DELEGATED DECISION TO DETERMINE PLANNING APPLICATIONS TO CARRY OUT DEVELOPMENT WITHOUT COMPLIANCE WITH PLANNING CONDITIONS PREVIOUSLY ATTACHED

Reference No:	2026/70/91609/E
Site Address:	land at, Westfield Farm, Barnsley Road, Flockton, Huddersfield, WF4 4DW
Description:	Variation of condition 2 (plans) on previous permission 2019/92238 for demolition of existing buildings, renovation of farmhouse and erection of 4no dwellings including garages and formation of new access
Recommending Officer:	Nicole Helliwell

Officer Report

DRAWING TITLE
UNITS 4 & 5 - GA DRAWING

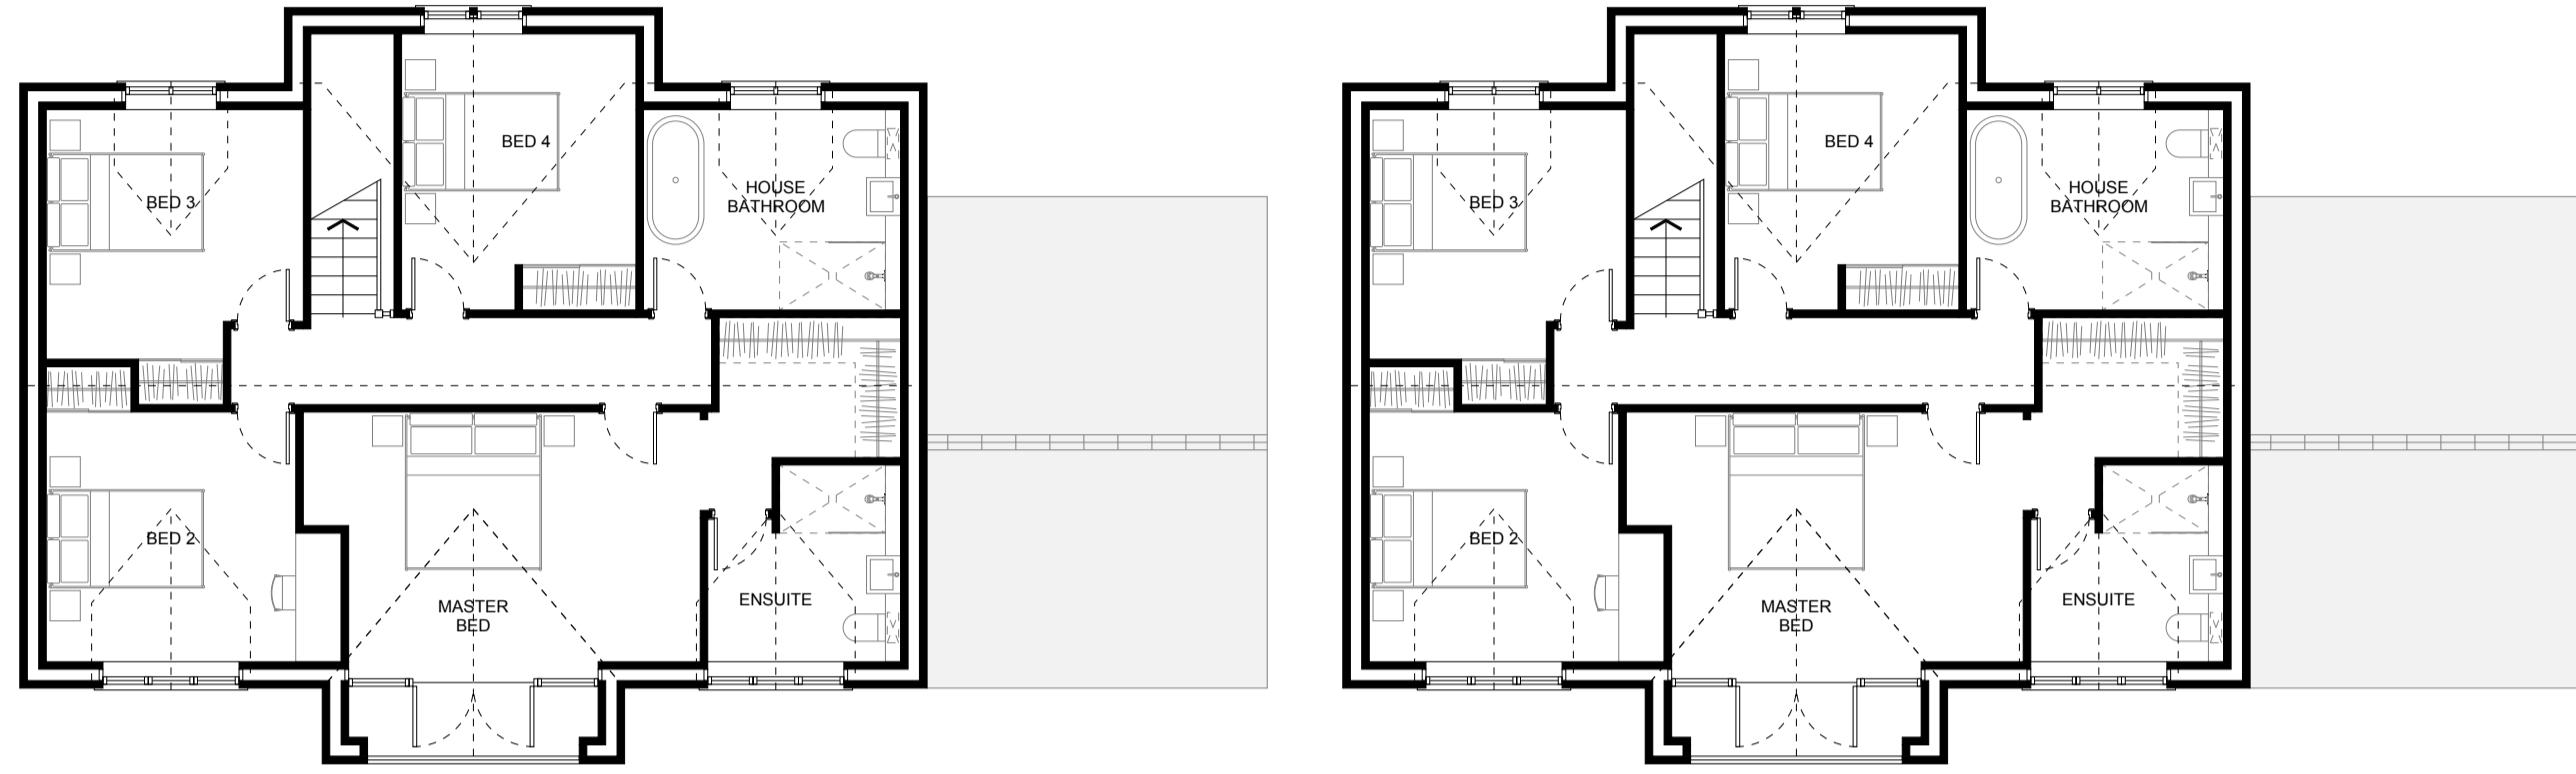
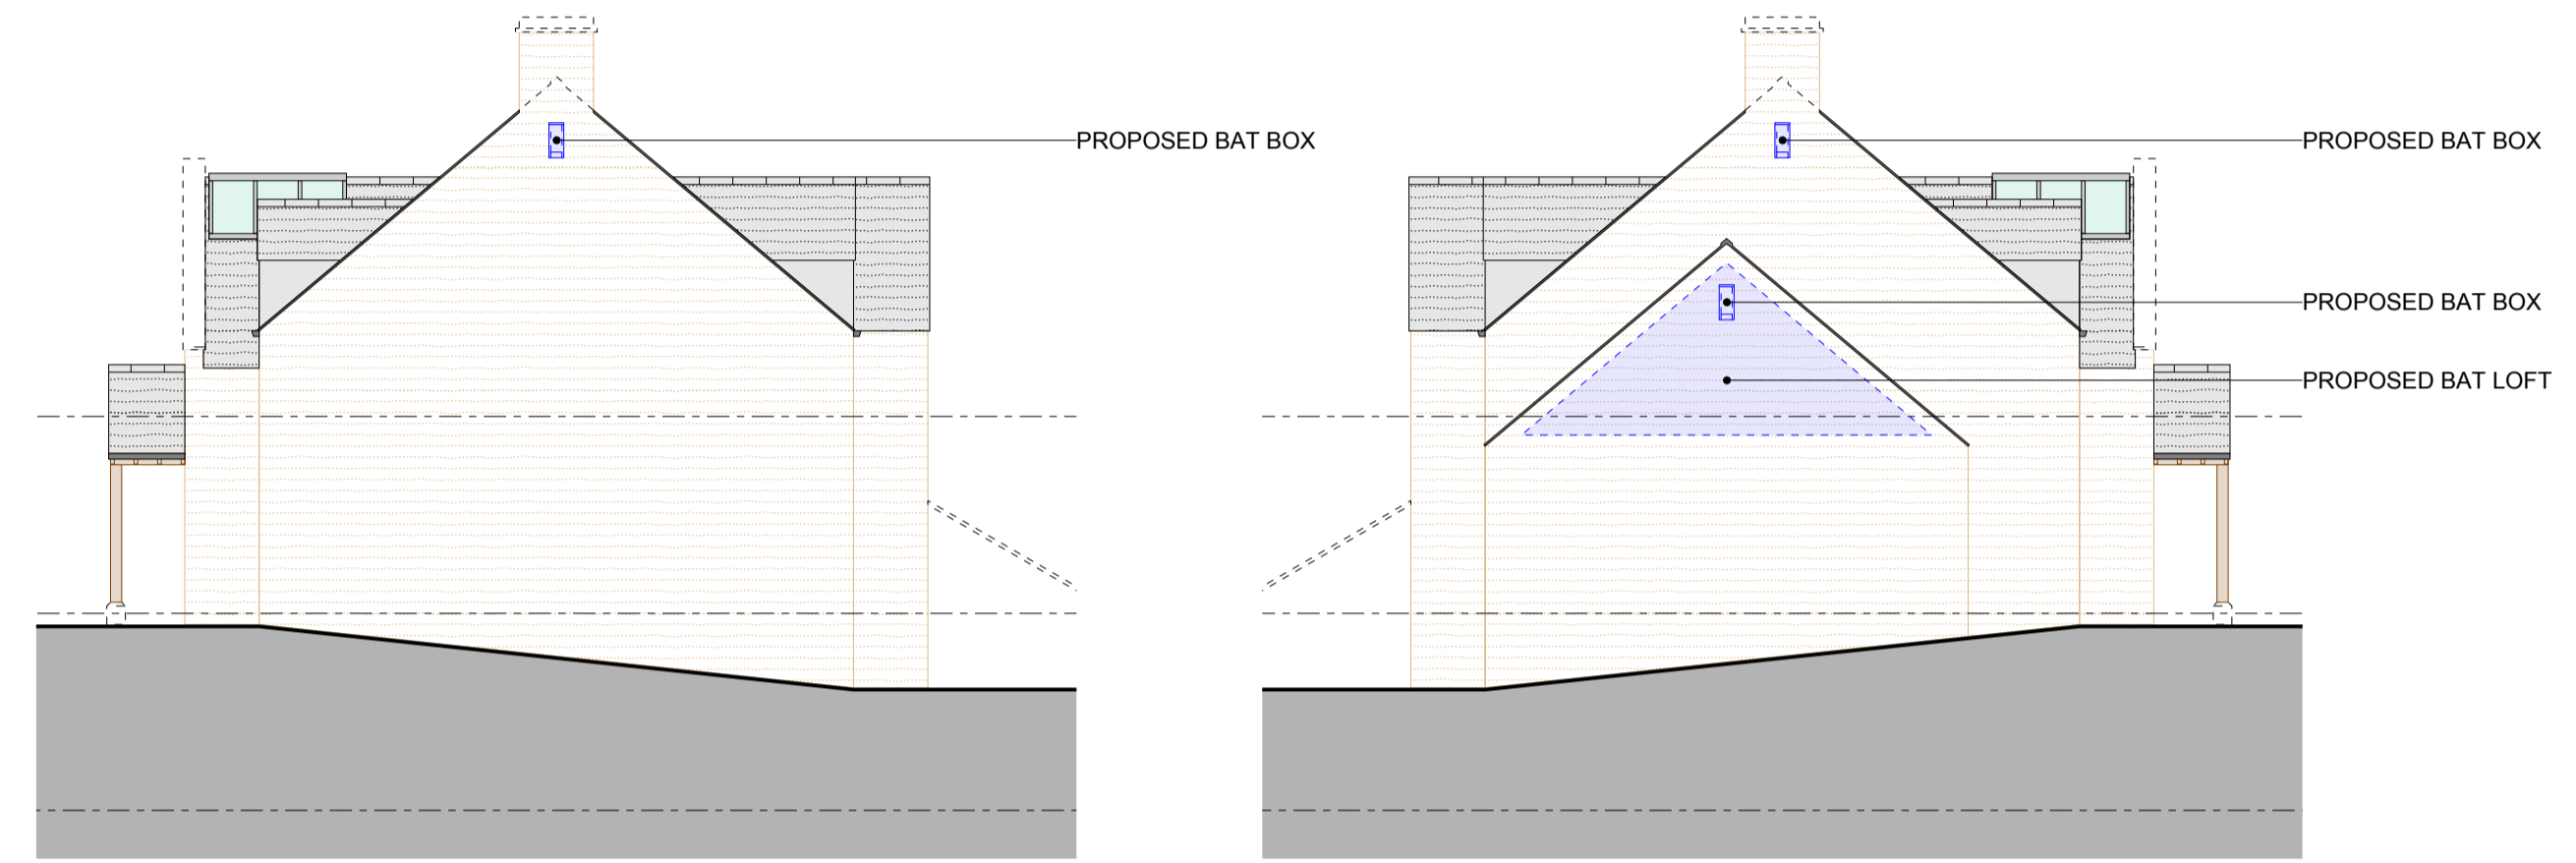
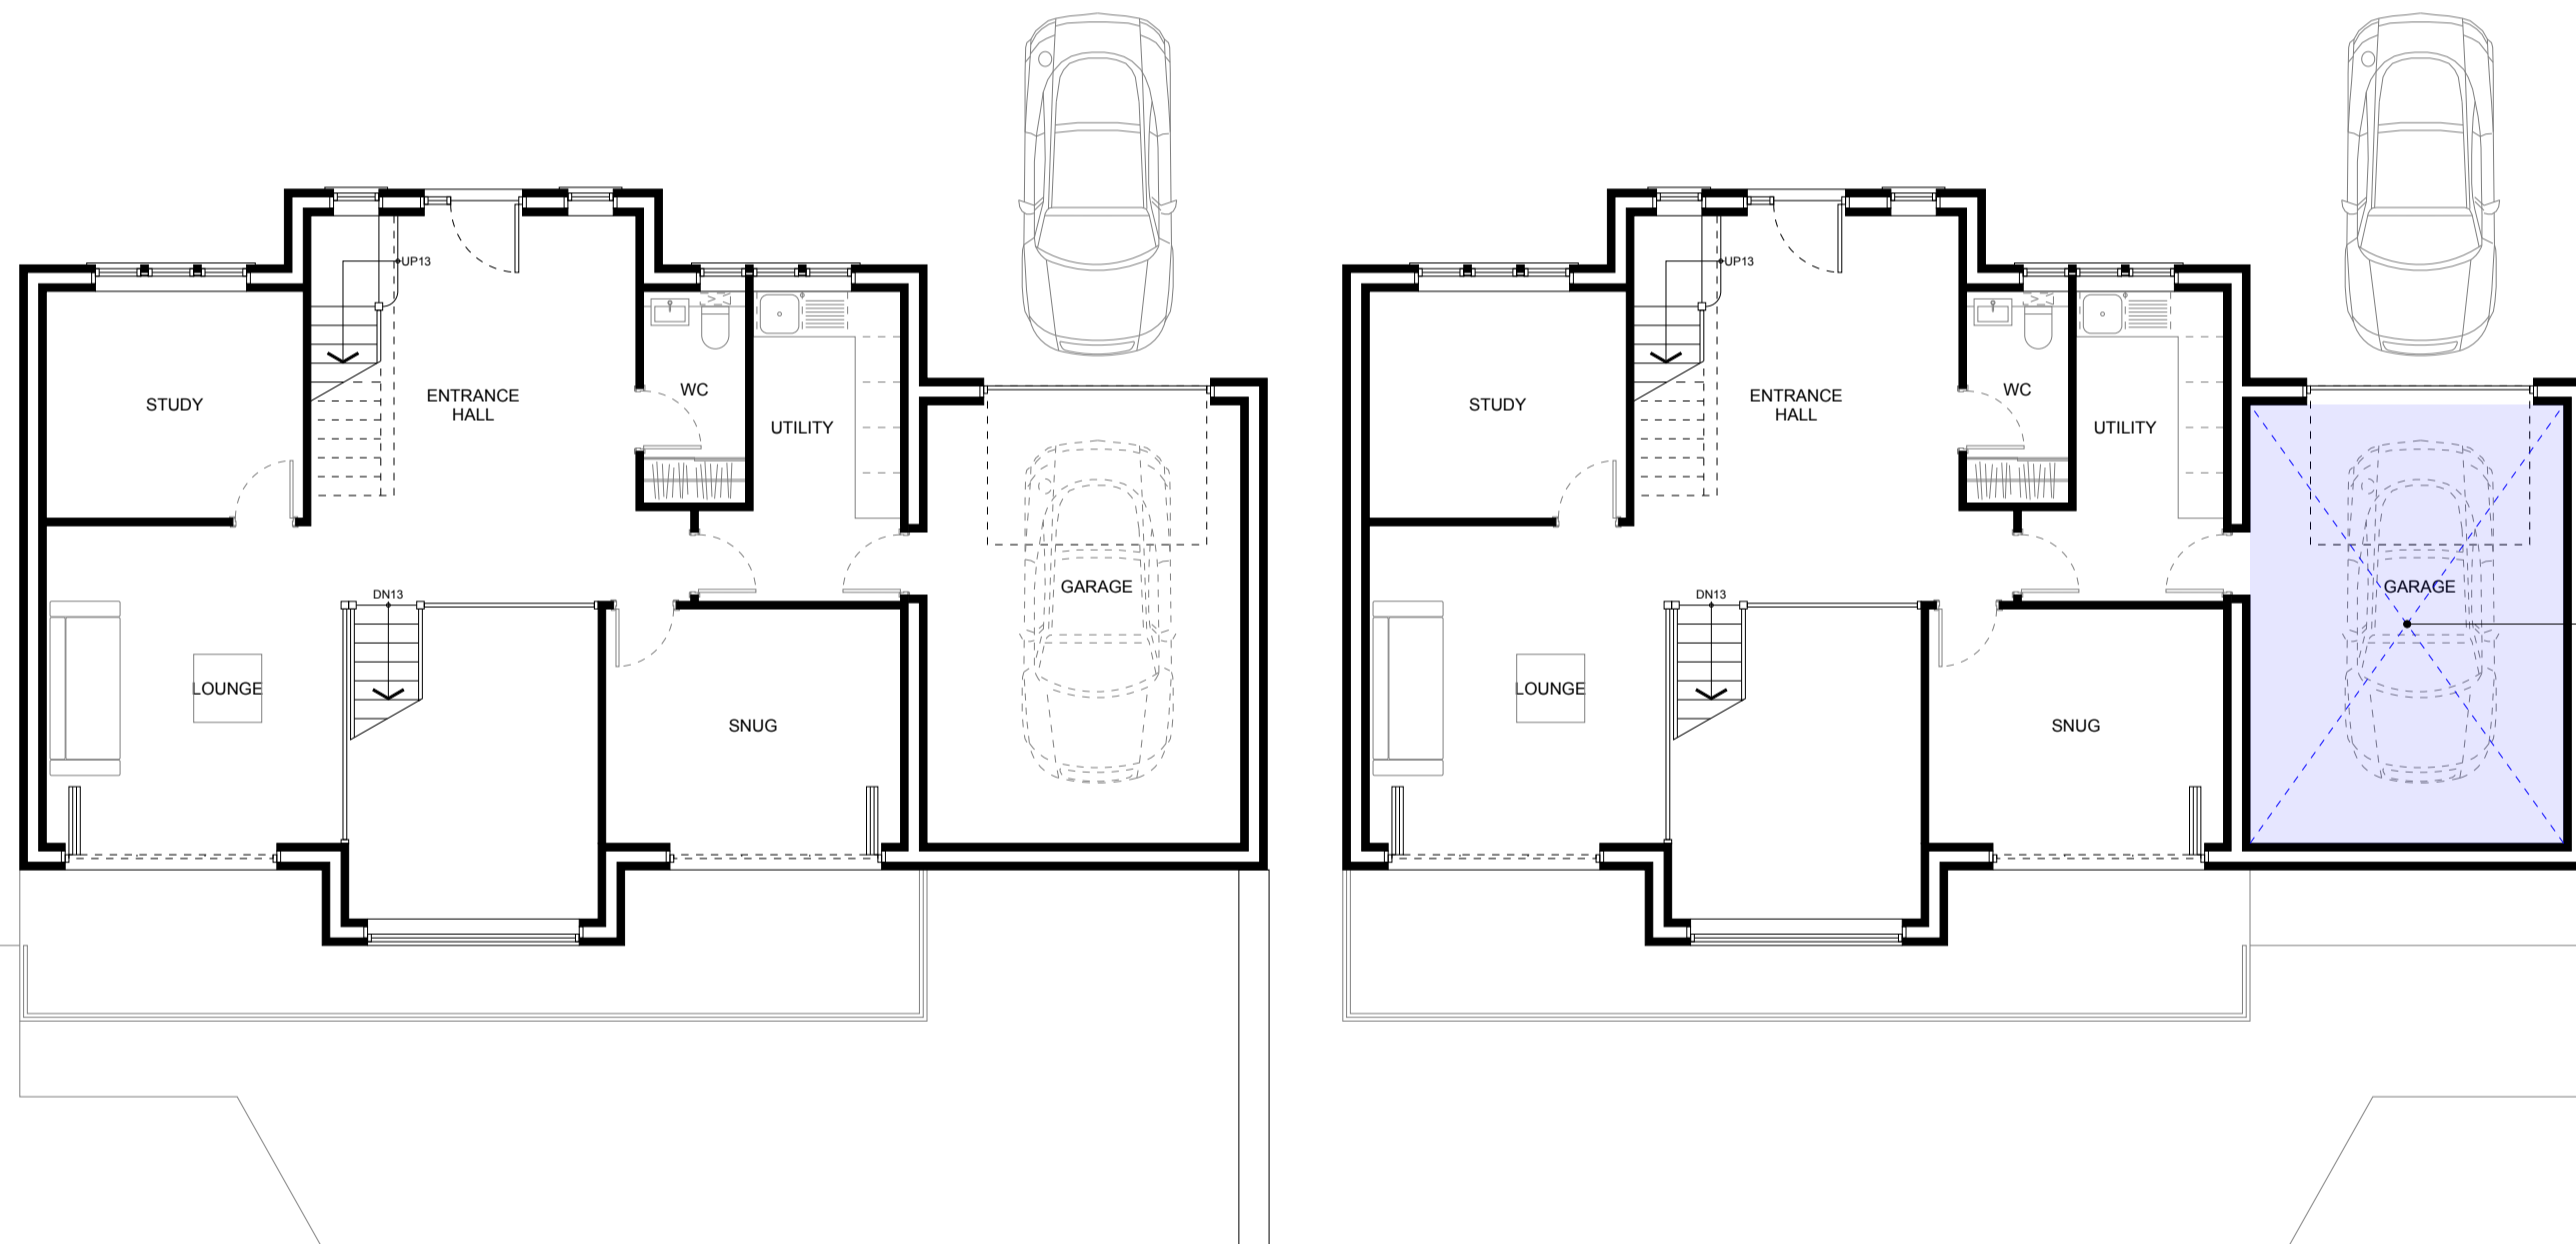
The submitted plans confirm that external alterations are proposed to create two detached split level properties. Units 4 and 5 would retain their traditional appearance from the northern elevation and would have a more contemporary appearance to the south. Whilst the overall scale and design of the dwellings would be altered as part of the variation, the resultant appearance is considered acceptable given that the dwellings would have limited visibility from public vantage points.

The dormer extensions would be located within the front and rear roof planes and would be of a traditional pitched roof design. Although no details have been provided regarding the material palette, a condition has been added requiring the dormers to be faced in materials to match the roof of the approved dwellings. Although the dormers would not be set back from the eaves, they would be sited below the ridge line and would not dominate the front and rear roof planes. The dormer windows would also be of an appropriate size and design and would generally align with the existing fenestration. Whilst it is noted that the area is generally devoid of dormer extensions, in this instance, the dormers are considered acceptable given the lack of uniformity within the street scene and that they would have limited visibility from public vantage points. Therefore, the proposed development would be acceptable from a visual amenity perspective.

The proposed canopies would extend approximately 1m from the northern elevations of Units 4 and 5 and would have an overall height of approximately 3.5m. Whilst it is acknowledged that front canopies are not a common feature within the street scene, it is noted that the structures would have a modest scale and would not appear overly prominent from public vantage points. Therefore, it is considered that the proposed amendment would be acceptable in terms of visual amenity.

Unit 1 and 2 are residential properties approved to the north of the application site. The submitted plans confirm that Unit 1 and 2 would occupy a position approx. 17m from the front elevation of Units 4 and 4. Although the separation distance would fall short of the 21m recommended within the Kirklees Housebuilders Design Guide SPD, it is taken into consideration that the approved relationship already falls short of this distance (2019/92238). Therefore, given that precedence has already been established within the street scene, the amendments are not considered to have a greater impact on the neighbouring occupants than the originally approved scheme.

Whilst no amendments are proposed to the access of the approved scheme, it is noted that the integral garages would be reduced in size as part of the application. However, the submitted plans demonstrate that off road parking would be retained at both units for three vehicles which would be an acceptable provision for a four bedroomed dwellinghouse. Therefore, the impact on highway safety is still considered acceptable and the proposal would comply with Policies LP21 and LP22 of the Kirklees Local Plan, Principle 12 of the Kirklees Housebuilders Design Guide SPD, advice contained within the Kirklees Highways Design Guide SPD and Chapter 15 of the NPPF.

16. Notwithstanding the submitted plans and information, the front and rear dormer extensions hereby approved shall be constructed in materials to match the roofs of the approved dwellings and retained thereafter.
